CIEE - Means of Egress

Wed, Jan 11, 2017 at 10:43 AM

**BASEMENT PLAN EXISTING**  
SCALE: 1/8" = 1'-0"

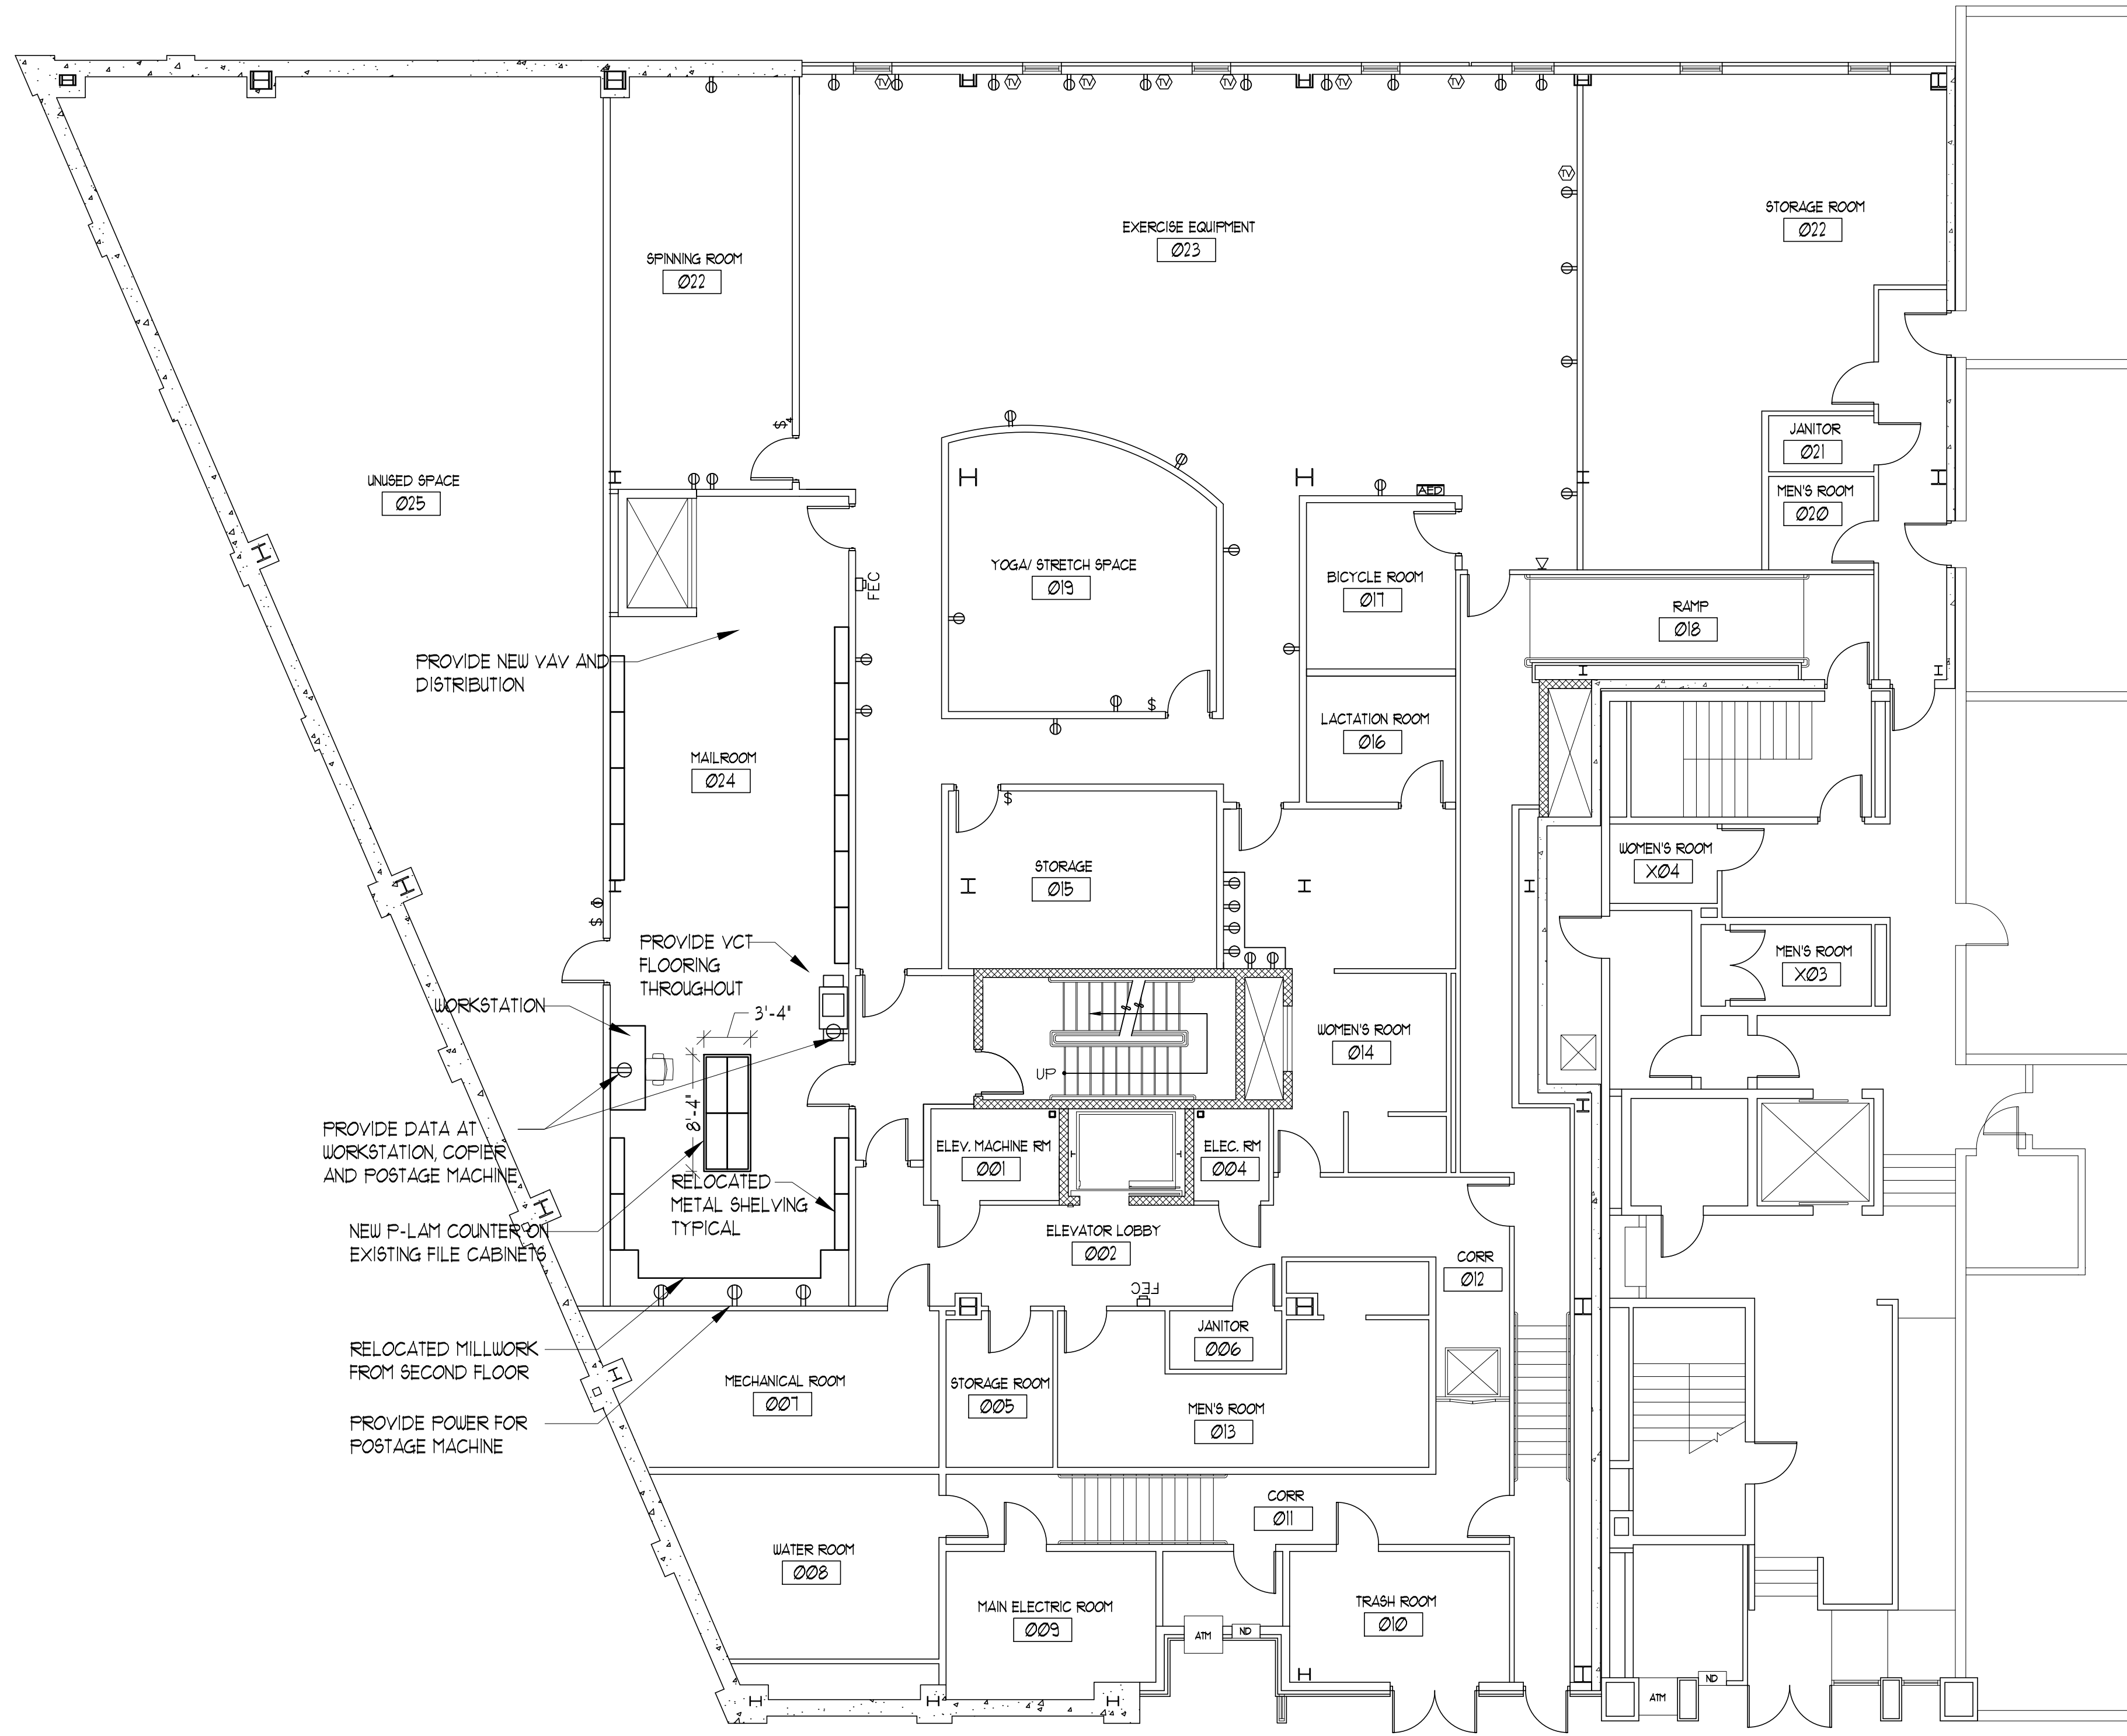
The drawings submitted show the door leading out of the stairway swinging in the wrong direction. It does actually swing out of the stairway along a means of egress (See image 0002). The corridor that this door leads to is a common corridor between the CIEE space and the adjacent tenant, the Old Port Sea Grill. This corridor does lead to an exit door onto the side street, Custom House Street (See Image 004).

Gensler has shown a means of egress from CIEE to be down the stairs and through the door shown in image 3, out into a 2 hour rated corridor in the basement (Jared confirmed this yesterday), that leads to a separate exit onto Custom House Street via the stairs show in image 001.

Thank you for the photos, Jared and I discussed the details this morning. I will be adding a condition of approval to the permit for the exit signage at the basement level in the stair enclosure from the CIEE space to direct travel to the left door as this is a continuous 2hr rated exit passageway. It is unclear if the common corridor to the adjacent tenant space beyond the right exit door is rated continuously to the exit discharge. This travel protection is required as only 50% of the exits can pass through an unrated lobby which is at the Fore St. level.
